Location of Construction: 45 Gleckler Rd		Owner: Mr. & Mrs. Steve McLaughlin		Phone: 775-2018		Permit No: 981334	
Owner Address:		Lessee/Buyer's Name:		Phone:		Business Name:	
Contractor Name: * Pock Carpentry		Address: 86 Grand St S.P. 04106		Phone:		<div style="border: 2px solid black; padding: 5px;"> PERMIT ISSUED Permit Issued: <div style="border: 1px solid black; padding: 5px; text-align: center;"> DEC - 1 1998 </div> CITY OF PORTLAND Zoning: R-3 CBL: 141-F-041 Zoning Approval: <i>ok</i> 11/30/98 Special Zone or Reviews: <input type="checkbox"/> Shoreland <i>N/A</i> <input type="checkbox"/> Wetland <input type="checkbox"/> Flood Zone <i>zone C</i> <input type="checkbox"/> Subdivision <input type="checkbox"/> Site Plan maj <input type="checkbox"/> minor <input type="checkbox"/> mm <input type="checkbox"/> <i>5,250⁰ - Sec 14.4%</i> Zoning Appeal <i>50%</i> <input type="checkbox"/> Variance <i>Setbacks ok</i> <input type="checkbox"/> Miscellaneous <input type="checkbox"/> Conditional Use <input type="checkbox"/> Interpretation <input type="checkbox"/> Approved <input type="checkbox"/> Denied </div>

BUILDING PERMIT REPORT

REASON FOR PERMIT: To Construct Full dormer

SECOND FLOOR PLAN
SCALE 1/4" = 1'-0"

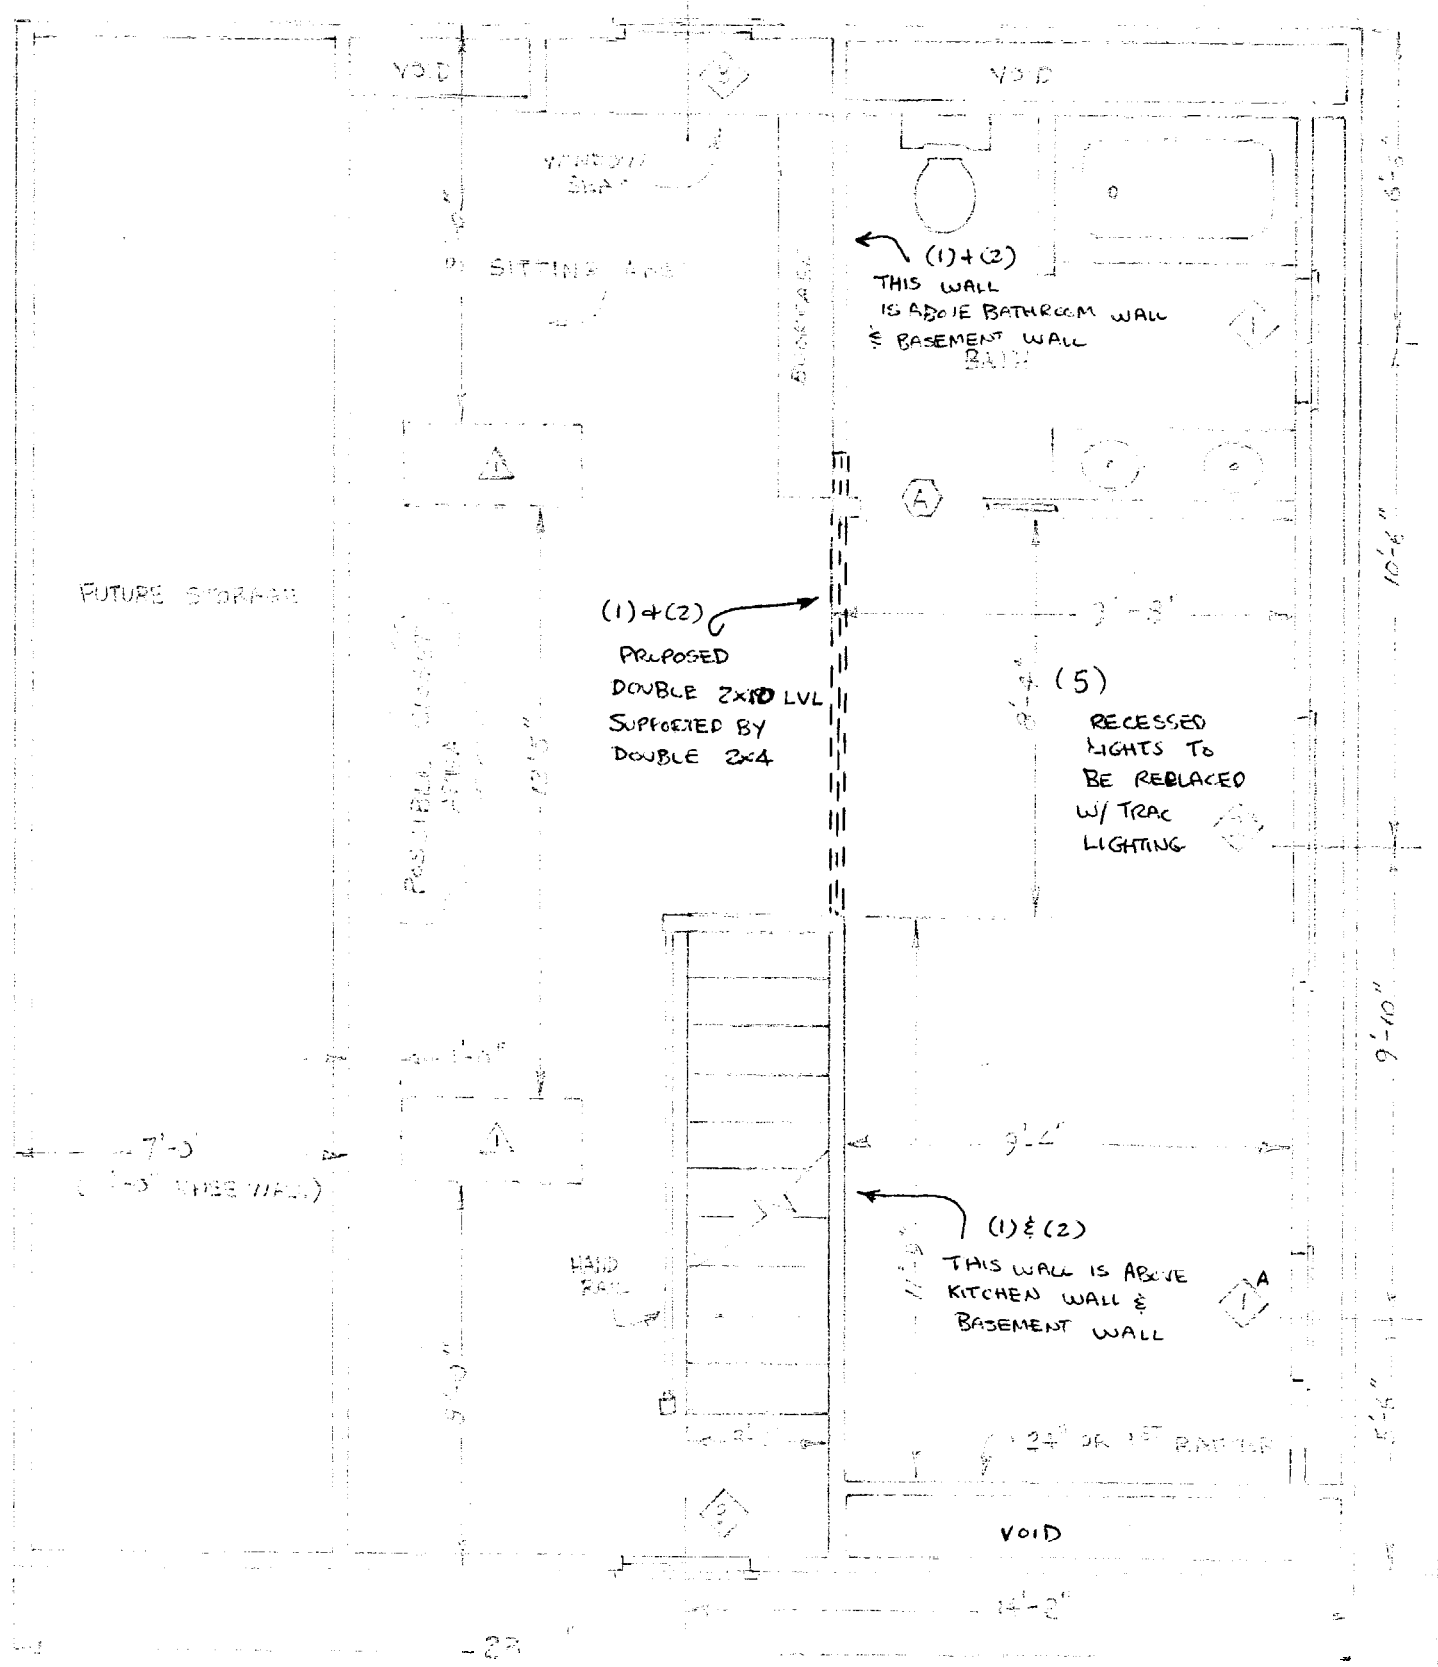
- *12. Every sleeping room below the fourth story in buildings of use Groups R and I-1 shall have at least one operable window or exterior door approved for emergency egress or rescue. The units must be operable from the inside without the use of special knowledge or separate tools. Where windows are provided as means of egress or rescue they shall have a sill height not more than 44 inches (1118mm) above the floor. All egress or rescue windows from sleeping rooms shall have a minimum net clear opening height dimension of 24 inches (610mm). The minimum net clear opening width dimension shall be 20 inches (508mm), and a minimum net clear opening of 5.7 sq. ft. (Section 1018.6)

FRAME DETAIL
SCALE 1/2" = 1'-0"

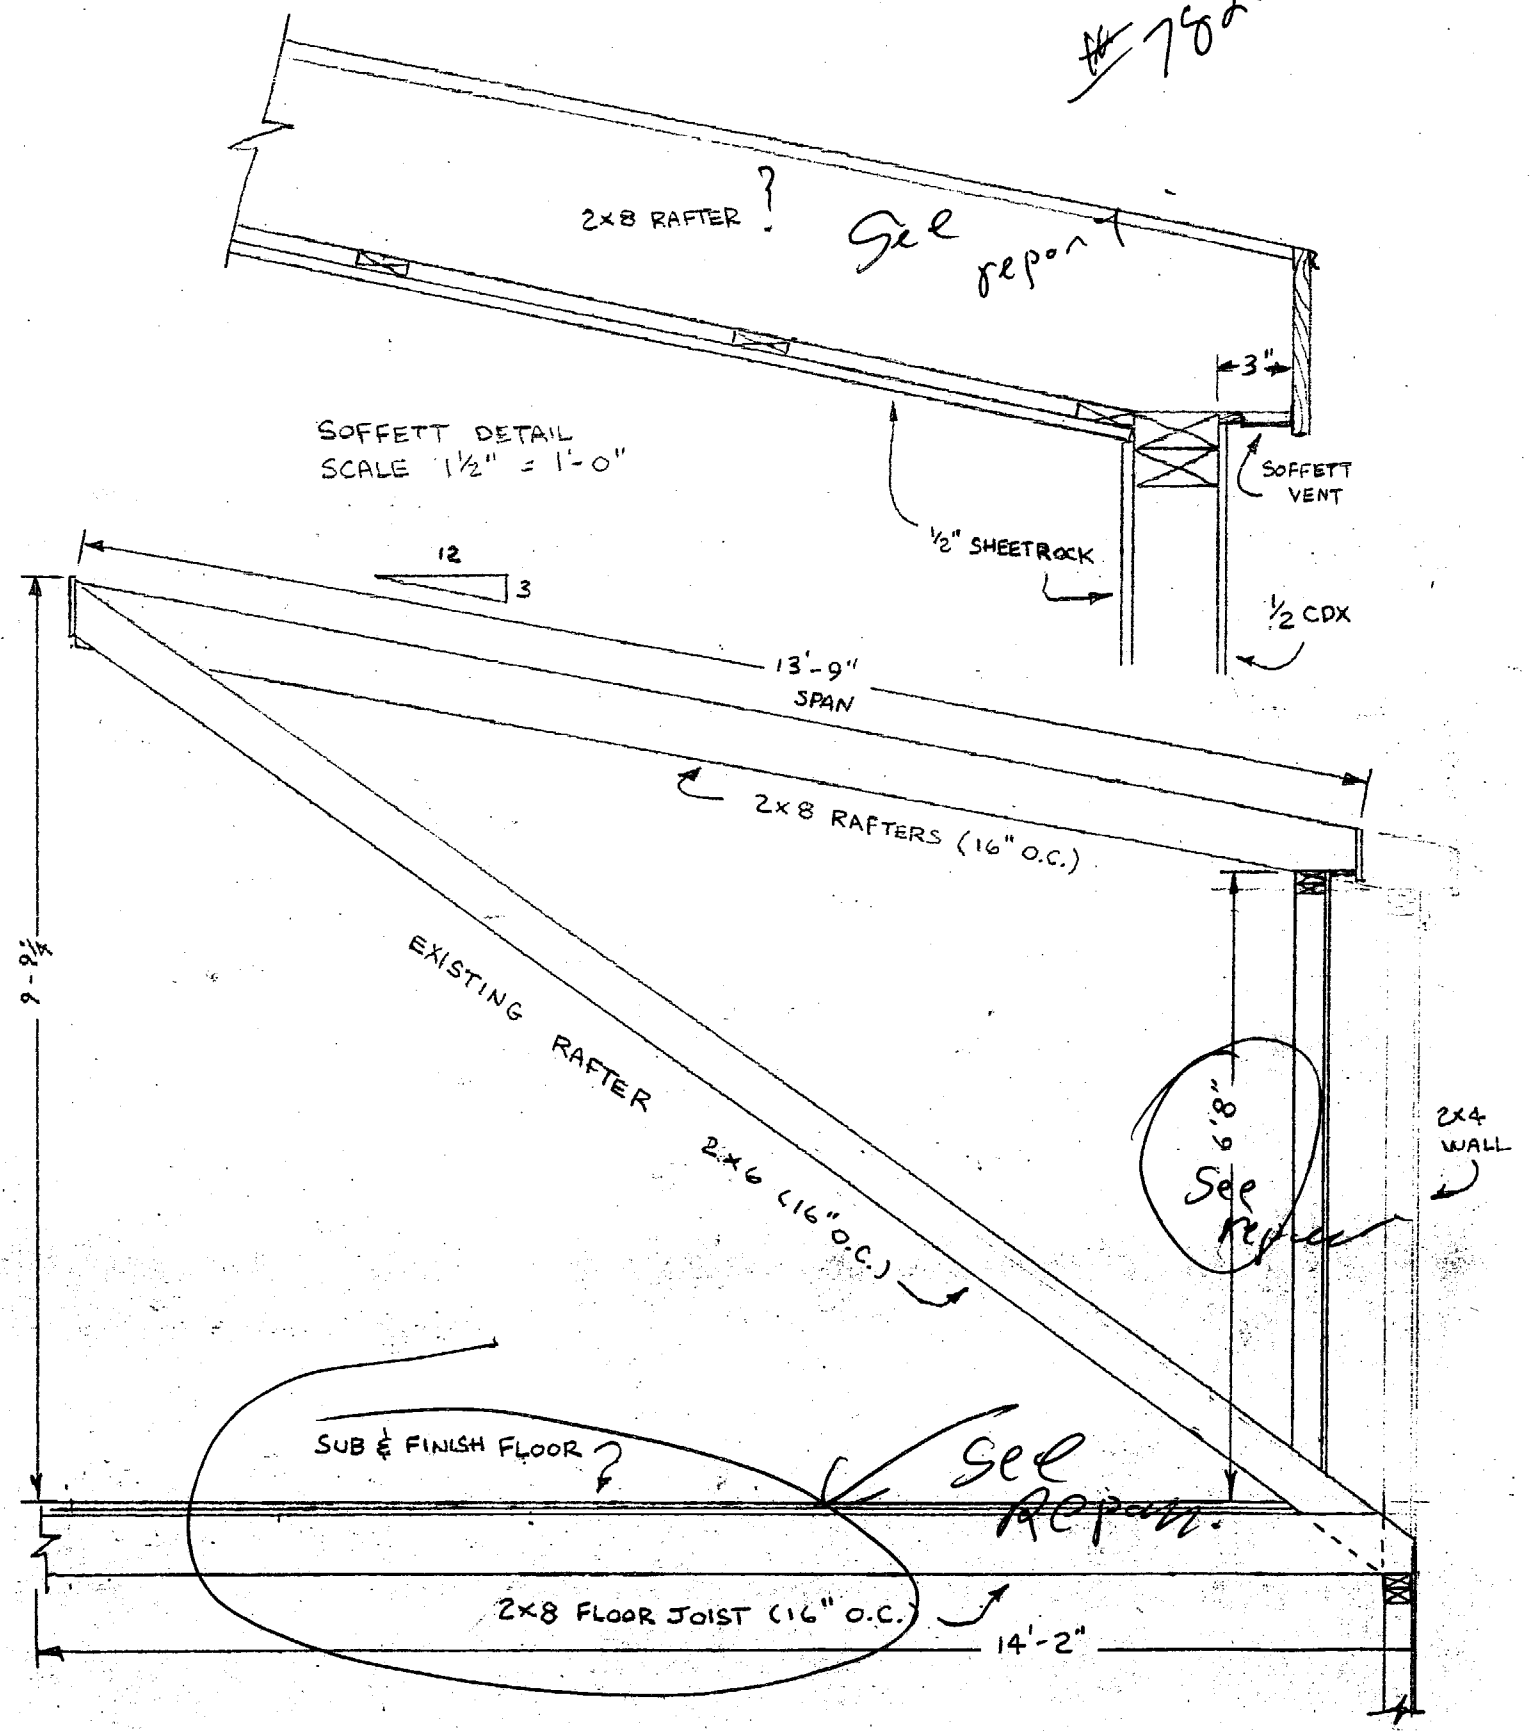
- 30. Glass and glazing shall meet the requirements of Chapter 24 of the building code.
- *31. The proposed 2x8 rafters @ 16" o.c., spanning 13'9" does NOT meet the requirement of the bldg. code - 2x8 @ 12" o.c. or 2x10 @ 16" o.c. will meet the code -

- *32. The 2x8 floor joist @ 16" o.c. spanning 14'2" with a 30 L.L. exceeds the bldg. code - you must submit revised plans showing an alternative method.
